From: Ward, Stuart [REDACTED]
Sent: 16 January 2018 11:45
To: Paul Cann; Planning.Responses
Cc: Jenkins, Samantha
Subject: RE: Planning Consultation on EG/107/17/DOC

From: Paul Cann [<mailto:Paul.Cann@arun.gov.uk>]
Sent: 15 January 2018 15:49
To: Planning.Responses [REDACTED]
Cc: Ward, Stuart [REDACTED]
Subject: RE: Planning Consultation on EG/107/17/DOC

Registered: 21-DEC-17
Site Address: 97 Barnham Road Eastergate PO22 0EQ

Description of Works: Application for approval of details reserved by condition
imposed under planning application EG/38/15/PL relating to
condition No. 3 - Surface water drainage

Number
S17-03-01 E

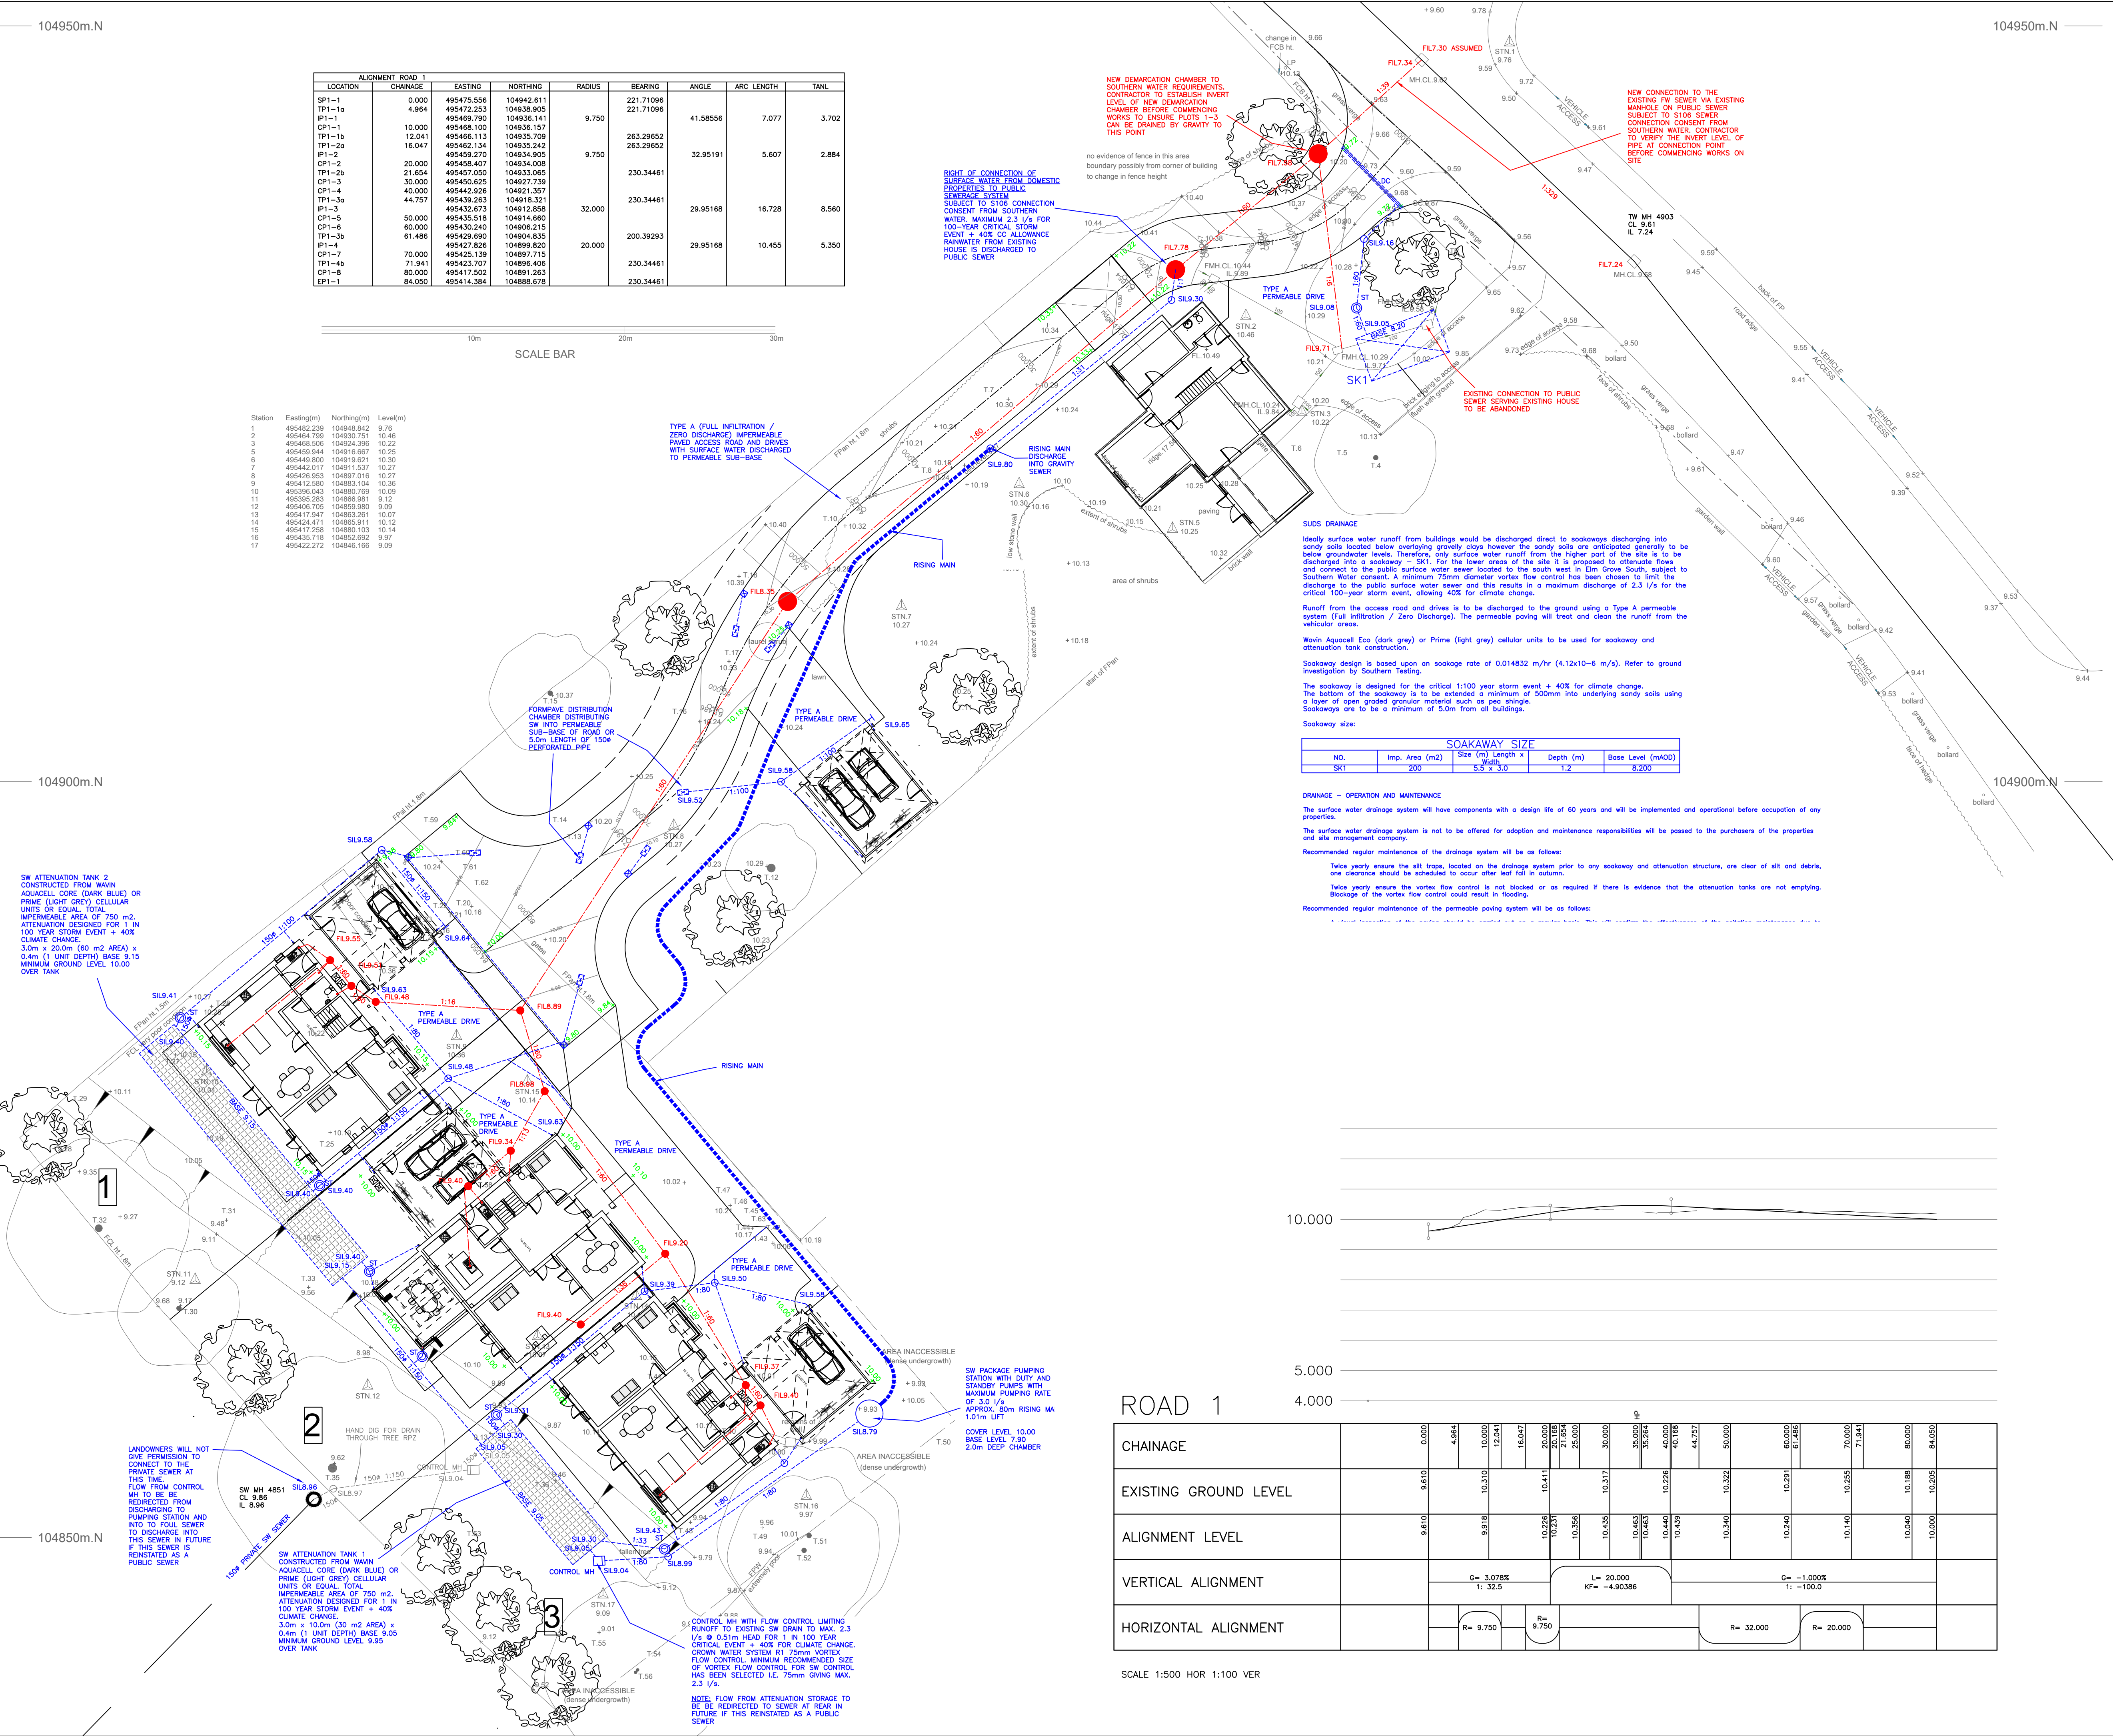
I would agree that the flow rate should not exceed the agreed flow rate of 2.3 l/s. They will need to amend the rate to the agreed flow rate (2.3 l/s) as any additional flows could lead to flooding downstream of the development site.

1. Provide full construction details of the package pumping station, including alarm arrangements in case of malfunction.
2. Specify rising main details (diameter/material/bedding) including thrust blocks.
3. The pump rate (note by pumping station) stipulates a max. flow rate of 3 l/s which is greater than the flow rate of 2.3 l/s required by Southern Water. Please provide confirmation from Southern Water that this is acceptable.
4. The final pipe before discharge to the foul manhole in the access road is proposed at a gradient of 1 in 1 which is too steep and will have a negative effect on foul flows within the sewer. Specify an external backdrop with soffit to soffit connection (with Southern Waters agreement).
5. The pumping station, etc will need to be maintained by the management company/residents.
